From: [REDACTED]
To: NorfolkVanguard@pins.gsi.gov.uk; [Norfolk Vanguard](#)
Subject: Norfolk Vanguard - Deadline 5 submission
Date: 20 March 2019 09:43:19

Can we make a personal Deadline 5 submission? This is based upon our recent submission to PINS Hornsea Three, but, as there does not seem to be a CTMP for Cawston on file from Norfolk Vanguard yet, we feel it is important to draw to your attention the fundamental flaws in the recent Hornsea plan. In terms of impact on Cawston the two proposed schemes cannot be viewed in isolation.

CAWSTON HIGH STREET - INTERVENTION SCHEME
Scale 1:500

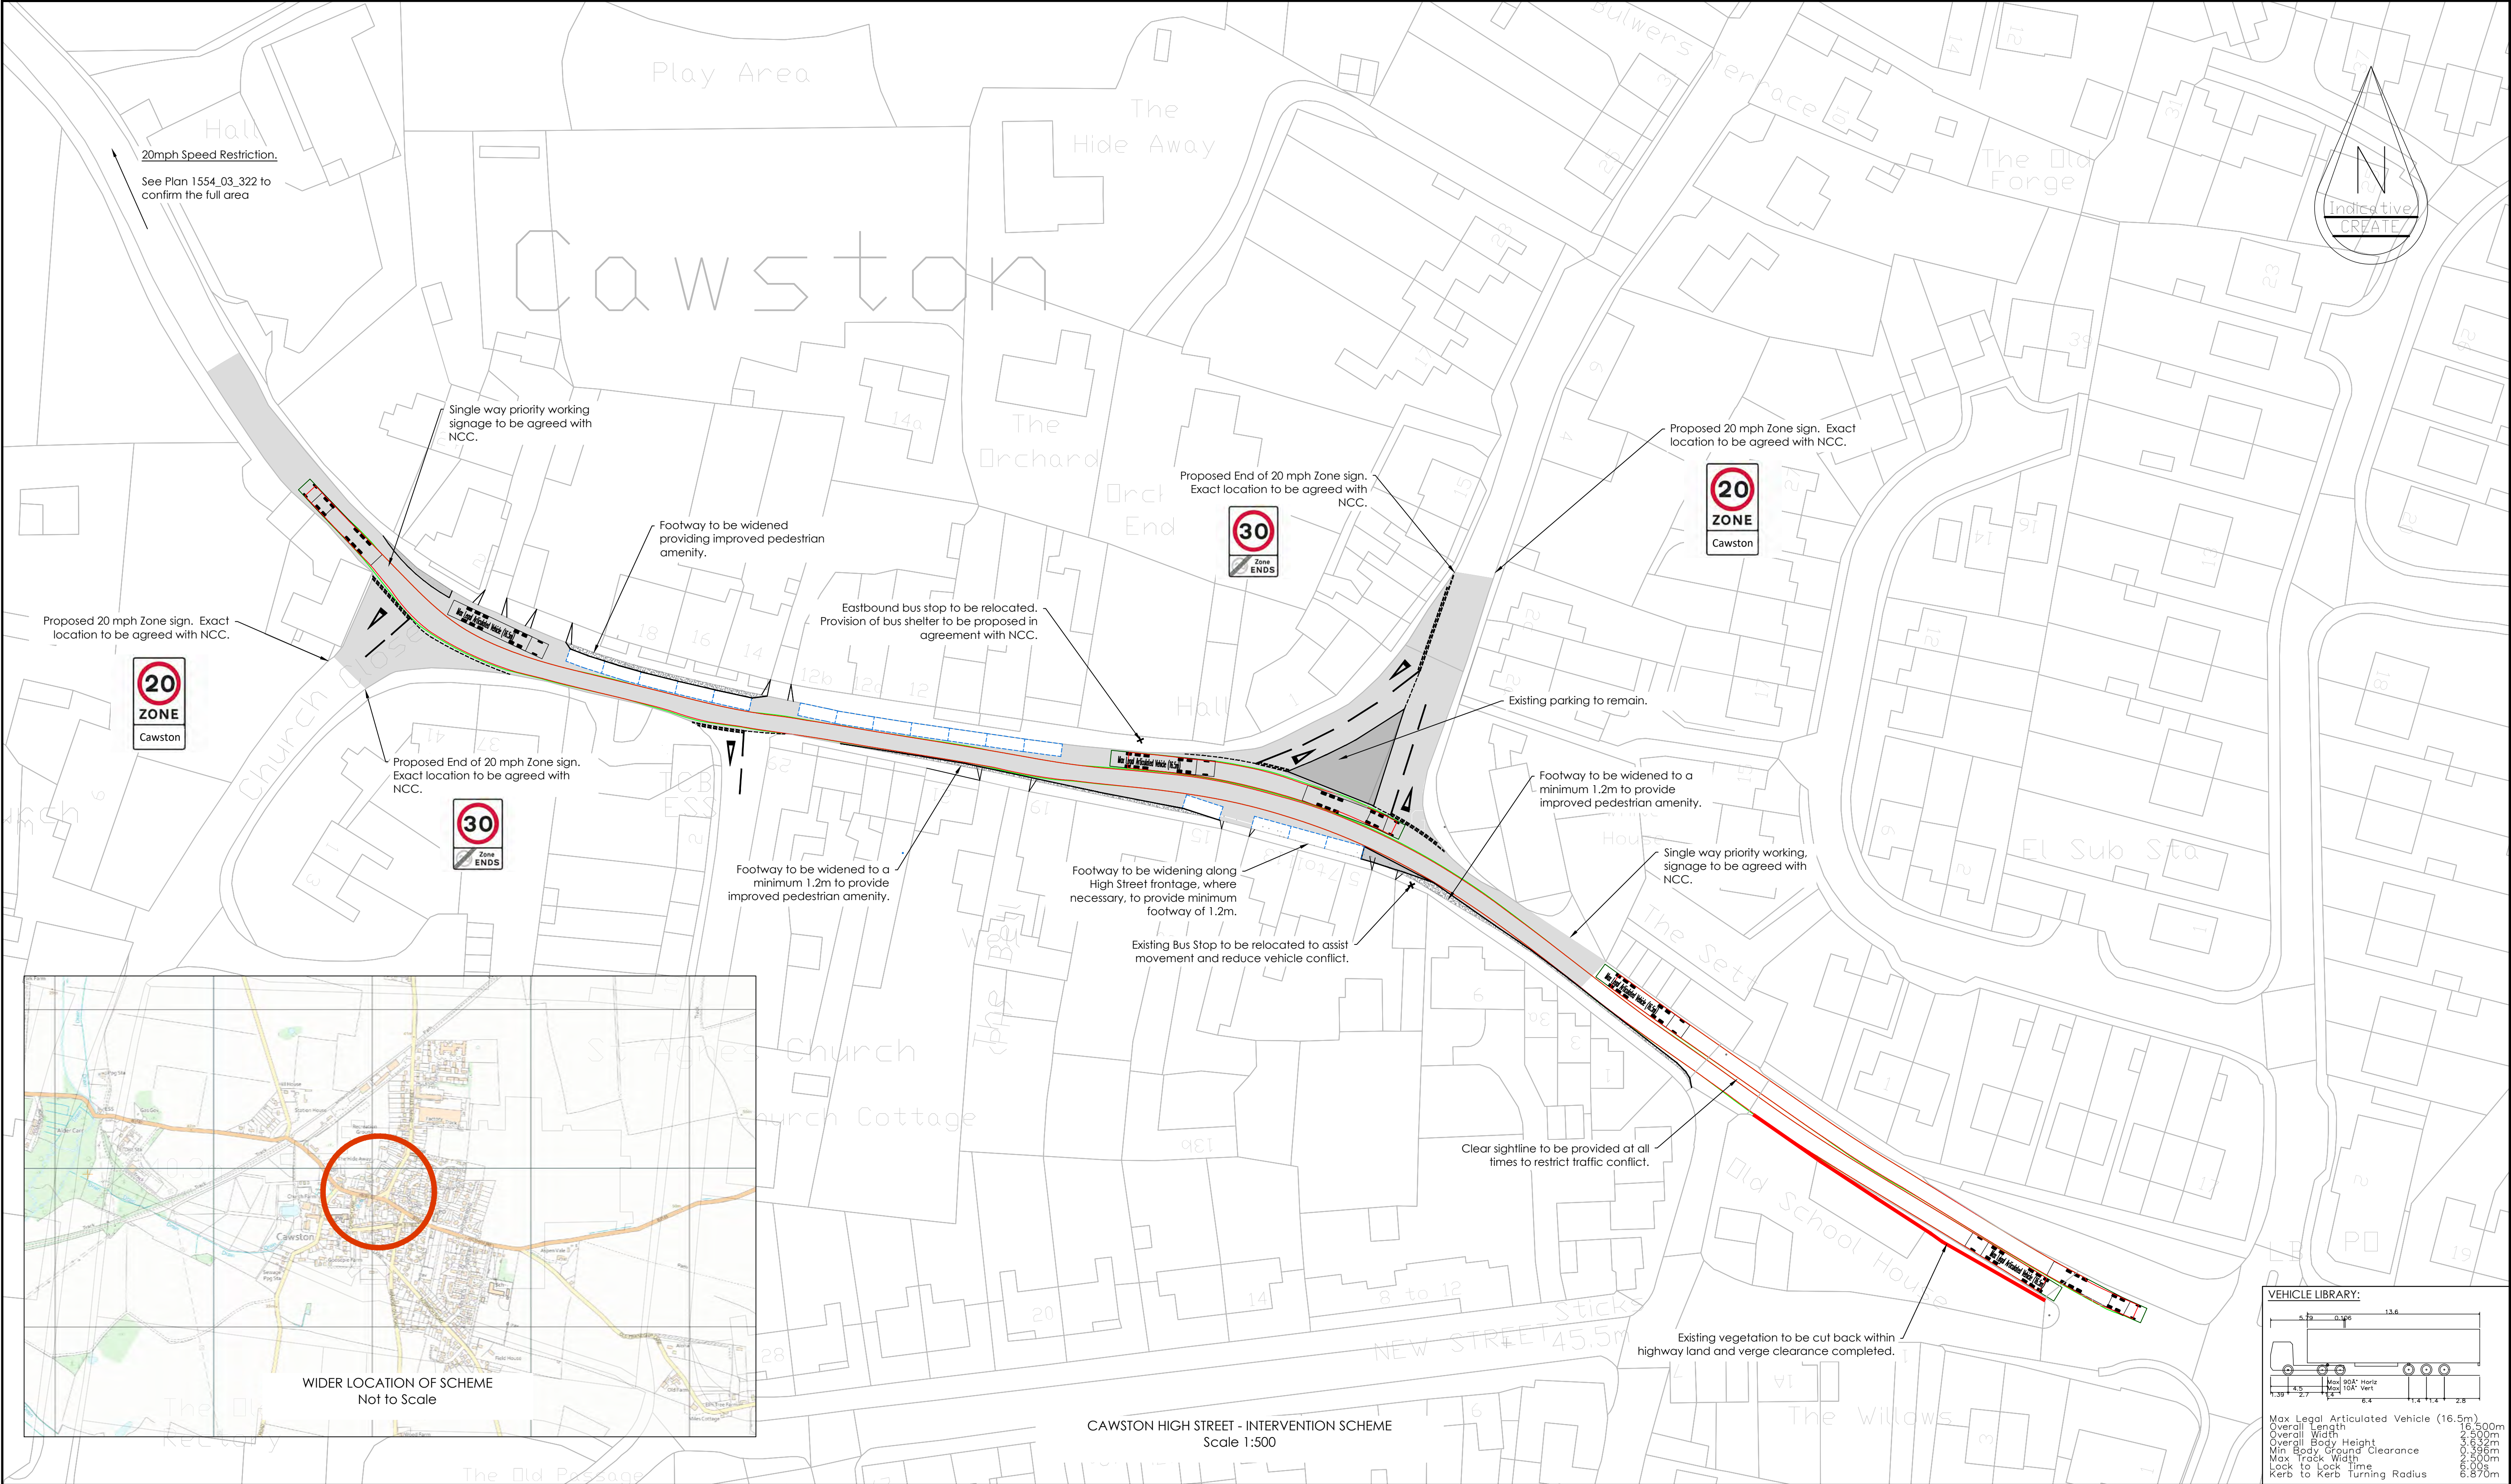
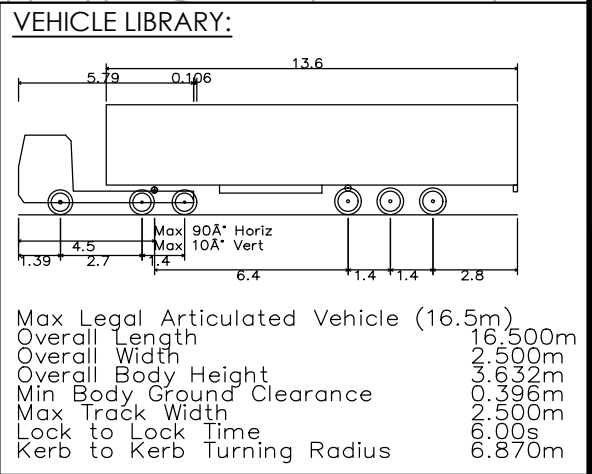
The latest traffic plan from Hornsea Three proposes to widen the footpath on both sides of the road and create a single lane section. They might argue that this merely formalises what happens now, but 'what happens now' does not include the additional traffic from Hornsea Three and Norfolk Vanguard.

It is also achieved by residents parking their vehicles outside their homes. Under the proposals this parking will be lost. Displaced vehicles will have to park elsewhere; the obvious choice is the narrow Church Lane, which will become congested as a result, probably blocking the three driveways (five households) that exit onto it.

All this traffic will be running up and down a single lane with houses close on both sides, in a busy pedestrian area. This will create a hour glass effect, with clusters of traffic building to the east and west of a pinch point in the central High Street. We don't understand how this can be managed safely.

What has not been mentioned yet is the effects of the road works necessary to implement the plan. Widening pavements, re-siting and adding signage and resurfacing the road will all bring further noise and chaos. It is hard to imagine how this work might be done without completely closing the road, and we would hope that no one has the temerity to do it at night in the middle of a residential area!
